## MEMORANDUM

**TO:** Jean Fraser, Planner  
**FROM:** David Senus, P.E. & Ashley Auger, E.I.T.  
**DATE:** January 10, 2013  
**RE:** 321 Commercial St. Mixed Use Development, Level III Final Site Plan/Subdivision Application

Woodard & Curran has reviewed the Response to Comments on the Level III Final Site Plan/Subdivision Application for the Mixed Use Development located at 321 Commercial Street in Portland, Maine. The project consists of a six story mixed use building with a 131 room hotel, 7,000 sq ft of restaurant space, and 14 residential units on the site of an existing gravel surface parking lot. The project proposes a net increase of 2,513 sq ft of impervious area on the site.

STORMWATER PLANTER PLAN  
SCALE: 1 INCH = 3 FEET

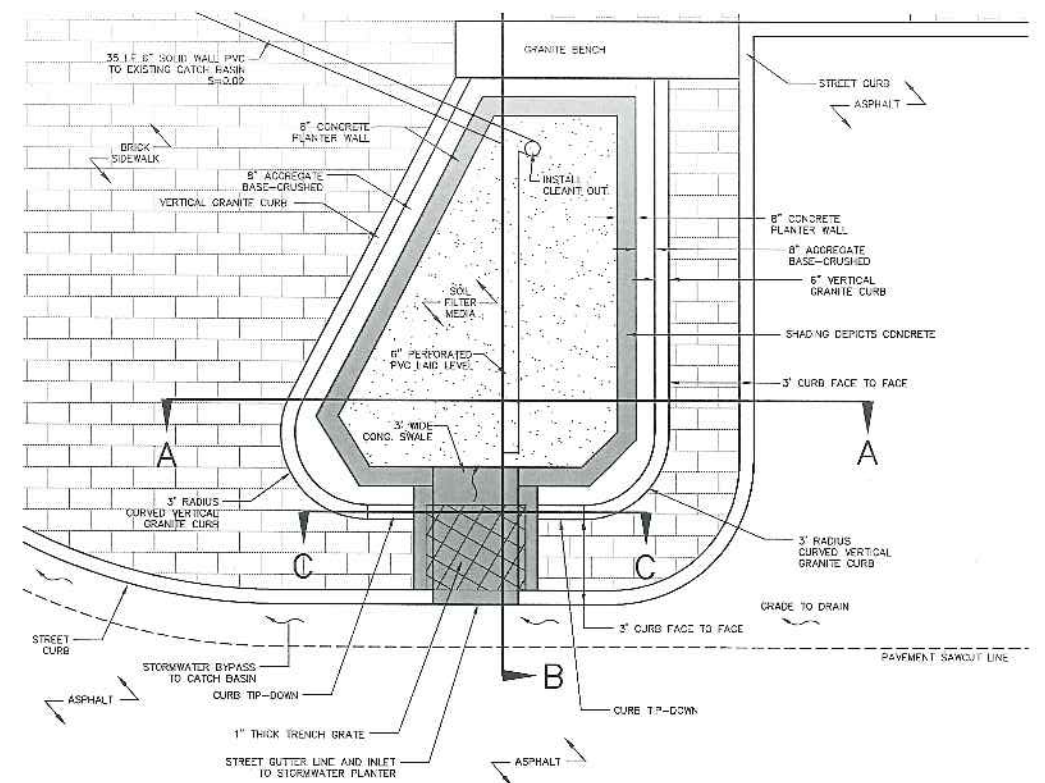
- a. The system appears to be designed to allow for the infiltration of stormwater into the underlying subsoil, as no underdrains are depicted on the plan or detail sheets. If the Applicant proposes to infiltrate stormwater with the system, the infiltration capacity of the existing subsoils should be evaluated to ensure that the system can infiltrate the design storm event (1" of runoff over 24 hours from the contributing impervious area). Alternatively, the Applicant may choose to install underdrains for the system, which must be connected to the City's storm drain system.

- b. The system is proposed within the Commercial Street Right-of-Way. As such, a stormwater maintenance agreement will be necessary between the City of the Portland and the Applicant to ensure that the Applicant is responsible for the ongoing inspection and maintenance of the system.
